Response to Queries raised by Environmental Health. Response in blue text below.

Application : A/52/20/PL Change of Use from Florist to barista coffee house/micro bar.

Address: The Enchanted Florist, The Square, Angmering, BN16 4AE

Date: 1st May 2020

EXISTING & PROPOSED PLAN 1:50

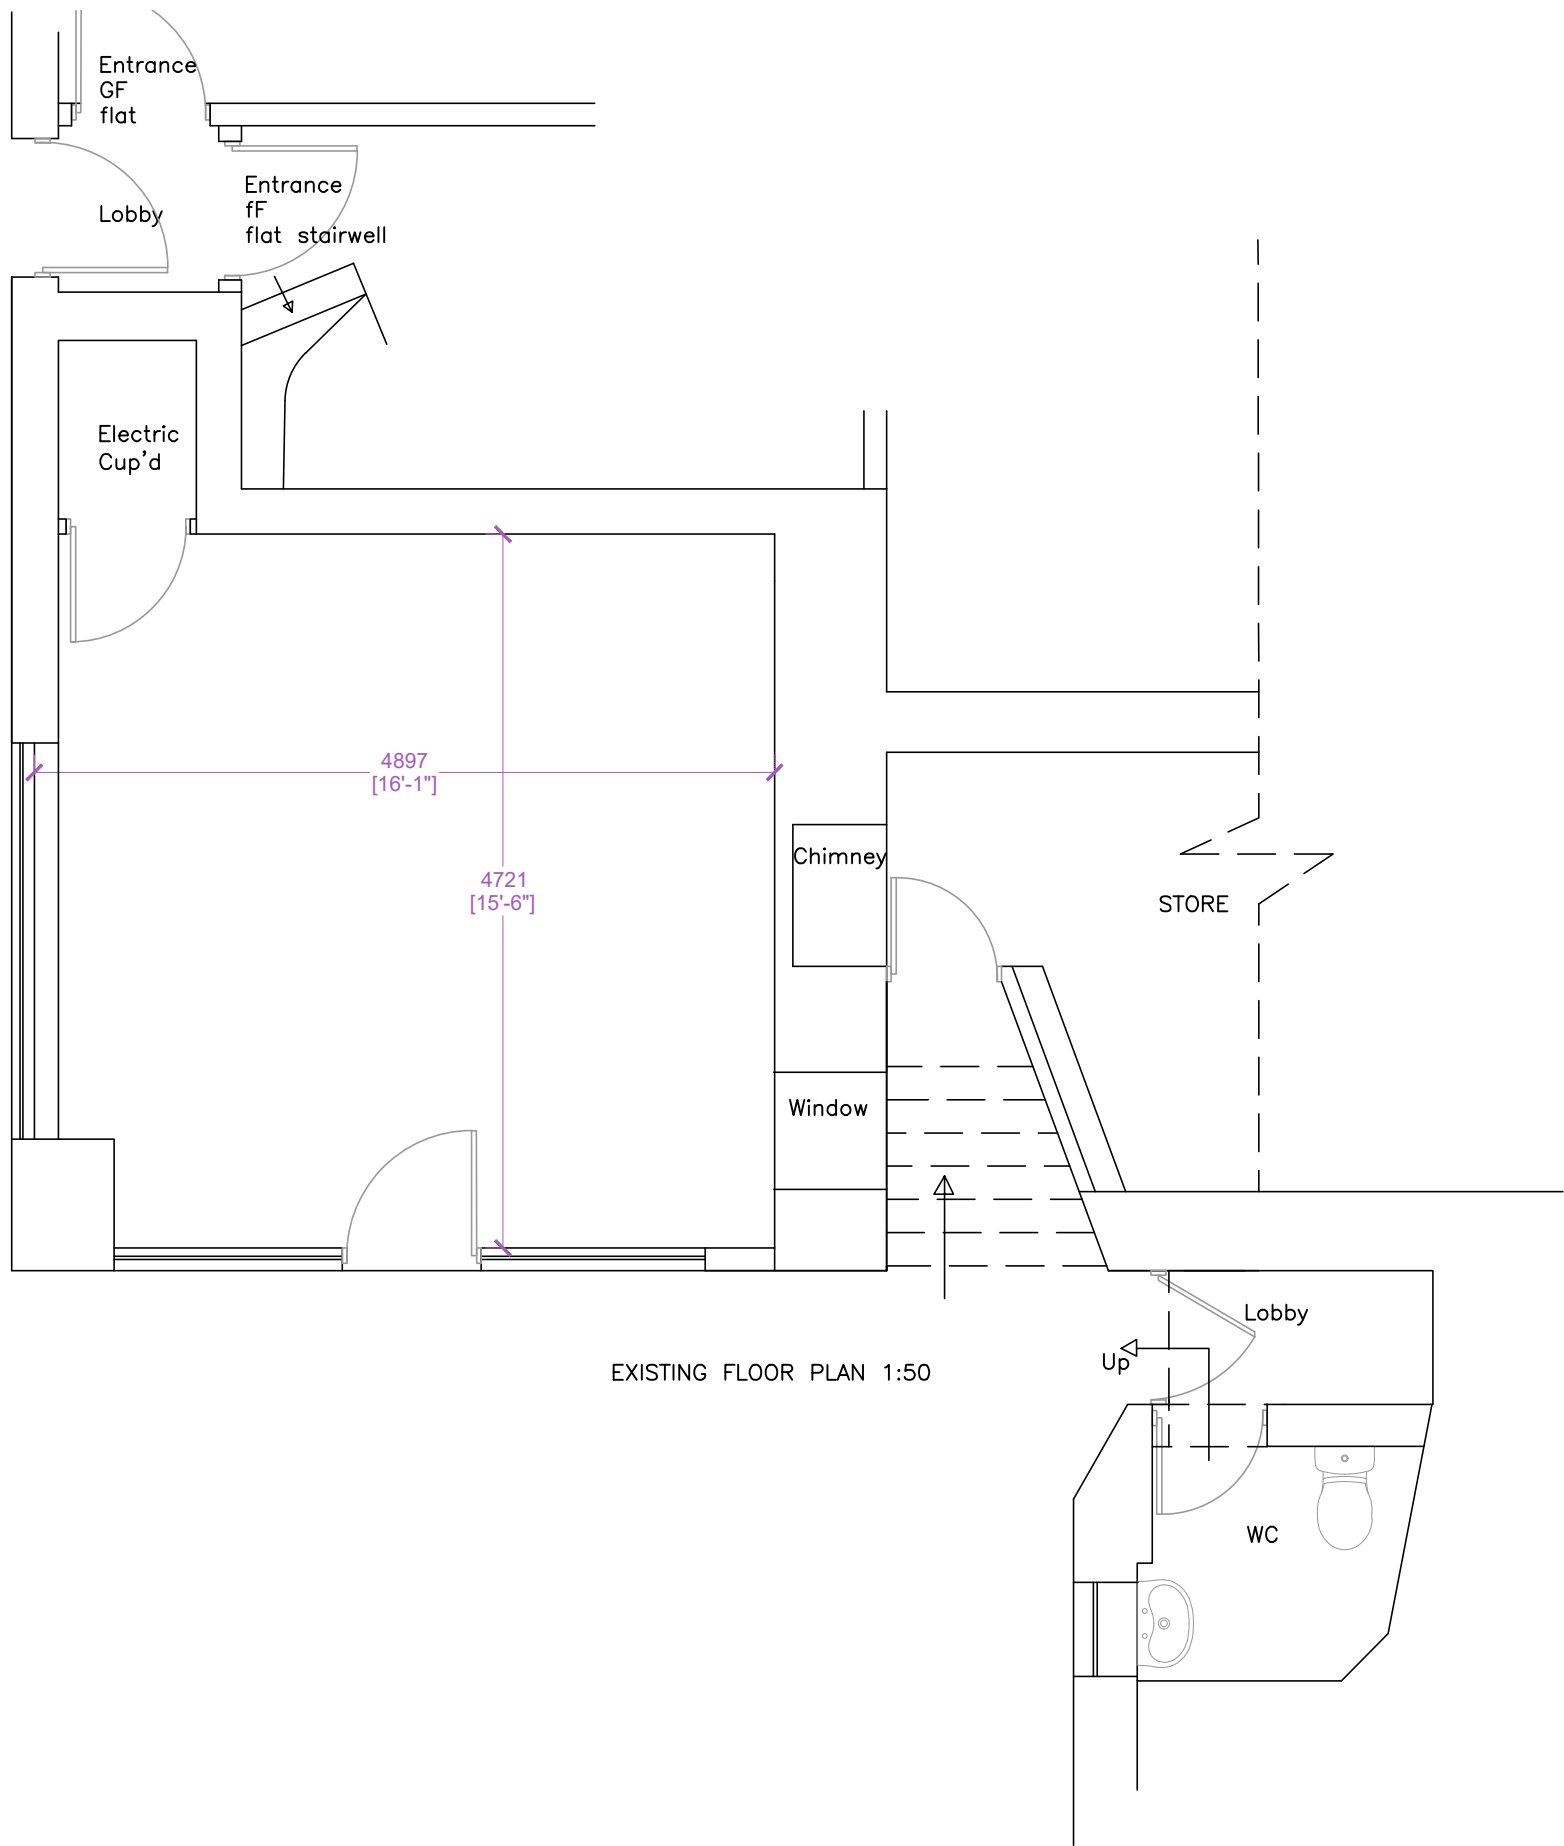
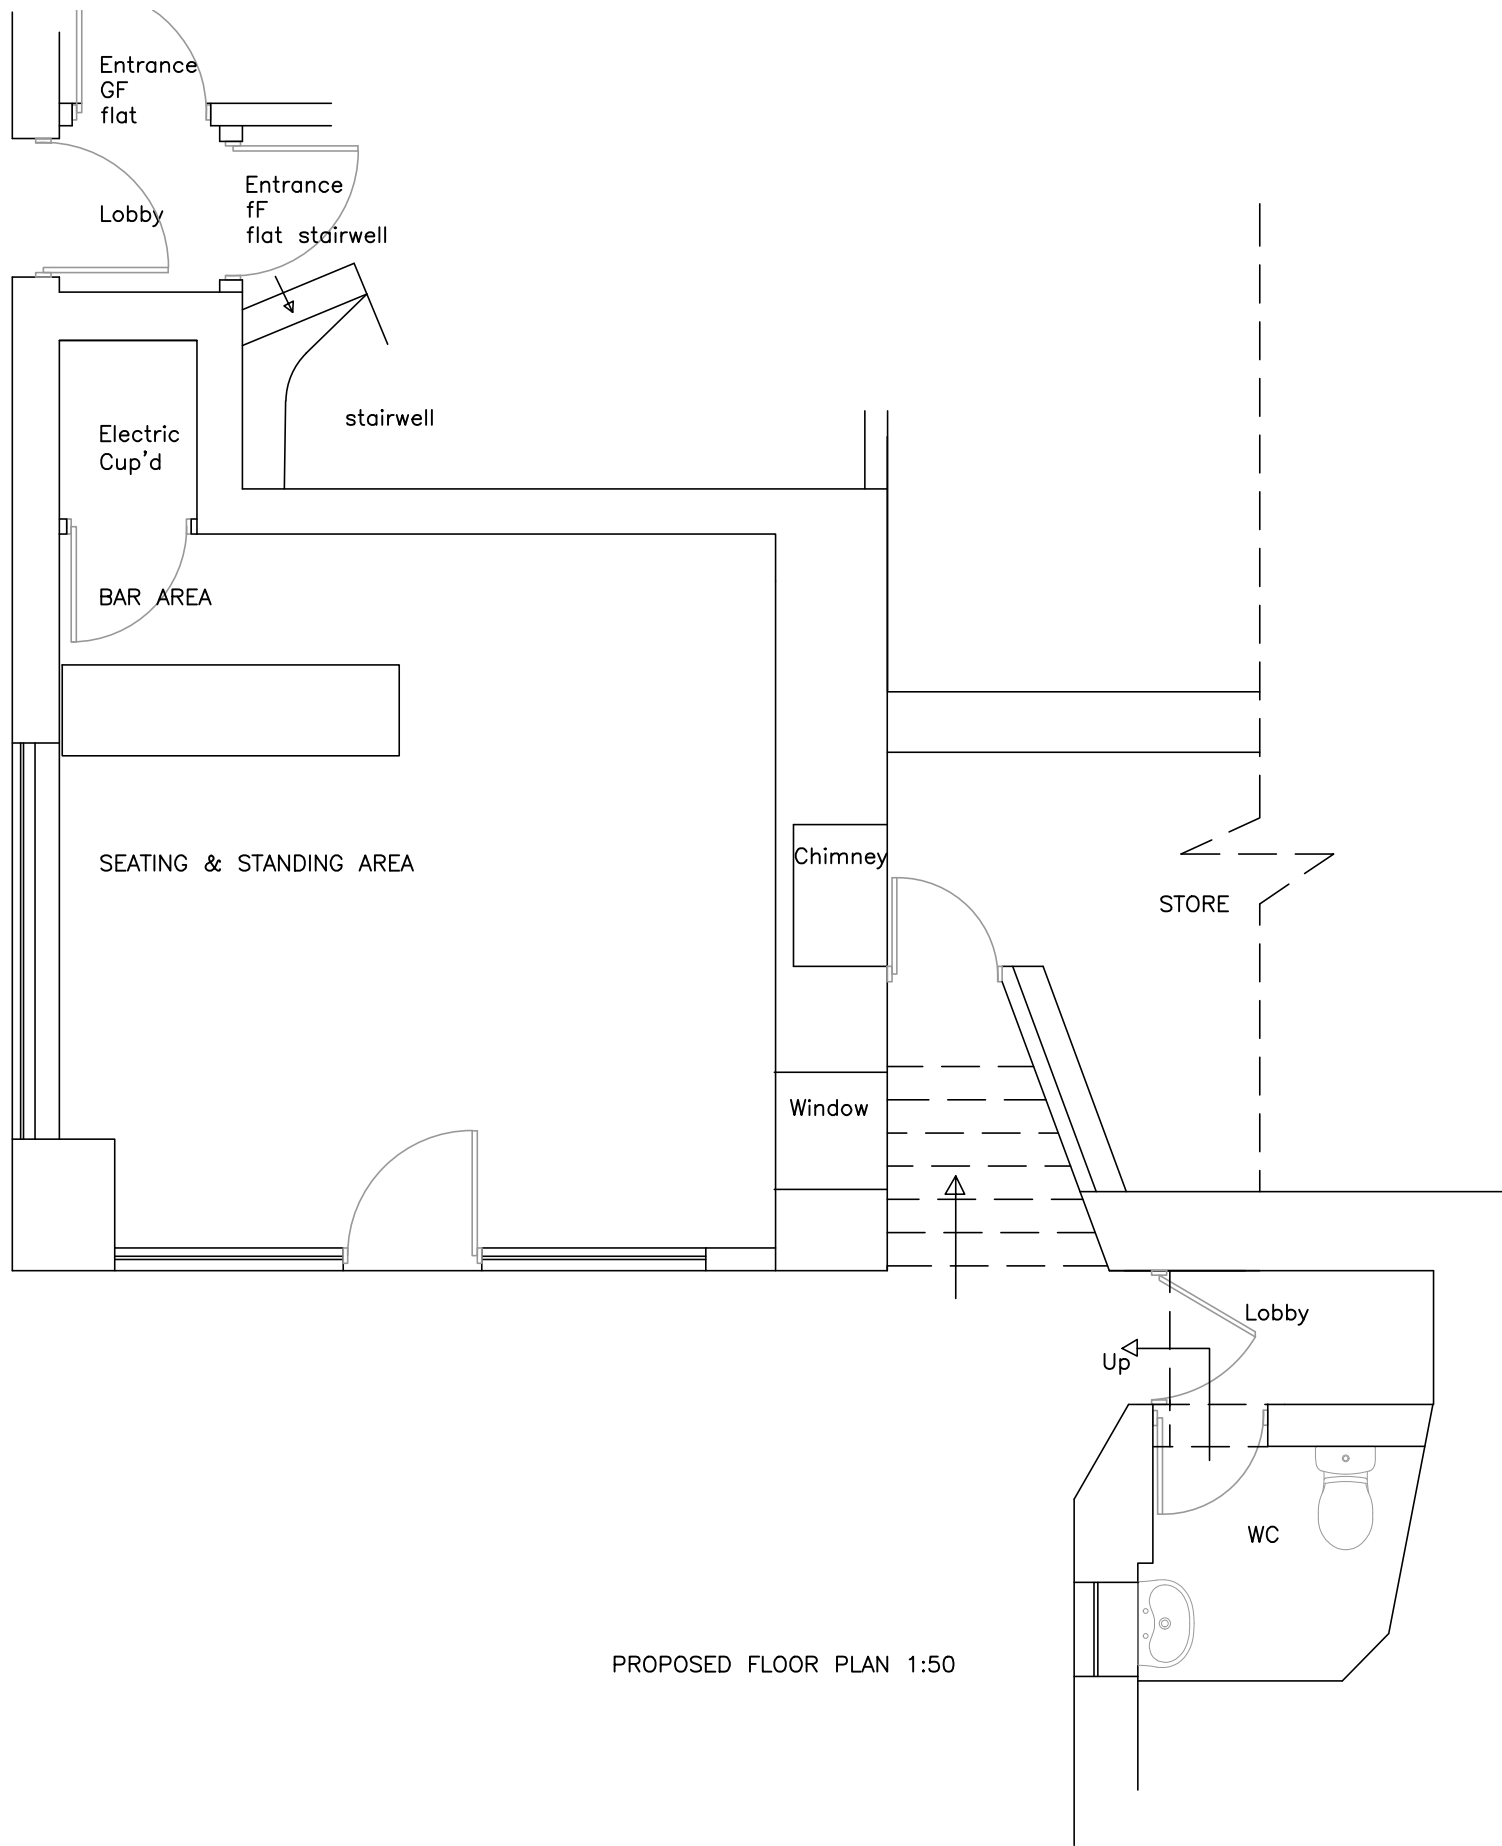
- whether there will be provision for a disabled toilet facility
 - The premises are set in a very old building and there is an existing WC adjacent to the unit (as shown on the drawings). Due to the restricted existing space it will not be possible to provide a disabled toilet.
- whether there is any cold store proposed
 - There will be not cold store. There will be an under the counter refrigerator for cold drinks.
- whether any ventilation/air-conditioning/heating is proposed
 - There will be no equipment requiring ventilation. There will be no air-conditioning or heating.

- The use hereby permitted shall not commence unless and until an insulation scheme for protecting the upper floor residential unit from noise has been submitted to and approved by the local planning authority. The scheme shall achieve a minimum airborne sound insulation value of 50dB (DnTw + Ctr dB) for all floors. Following approval and implementation of the scheme, a test shall be undertaken to demonstrate that the attenuation measures carried out as part of the approved scheme are effective and achieve the specified criteria. All works, which form part of the approved scheme, shall be completed before the use commences. **Reason:** To protect the amenity of local residents in accordance with Policy QE DM1 and D DM1 of the Arun Local Plan.
➤ NOTED. CEILING TREATMENT AS FOLLOWS. PLEASE COULD WE HAVE APPROVAL OF THIS SCHEME AS APPROPRIATE. SOUND TEST TO BE PROVIDED ON COMPLETION OF WORKS

- Chicken wire attached to the underside of the existing lathe plaster ceiling with 38x38mm timber battens. (contractor to confirm the ceiling fabric is lathe & plaster prior to commencement)

- 2 layers 15mm Gyproc sounbloc attached to the ceiling (or battens if fitted) to provide 60min FR and soundproofing.
 - 277mm void with 100mm Isover
 - Casoline MF Gyproc suspended ceiling system

- 2 x 15mm Gyproc soundbloc
 - Taped and joint or plaster finish
- Notwithstanding the provisions of the Town and Country Planning General Permitted Development Order 1995 as amended (or any order revoking and re-enacting that Order with or without modification), the premises shall be used only as a micro-pub as described in the supporting material submitted with the application and for no other purpose within Use Class A4 of the Town and Country Planning (Use Classes) Order 1987 or in any equivalent to that Class in any Statutory Instrument revoking and re-enacting that Order with or without modification, except by grant of a separate planning permission by the local planning authority.
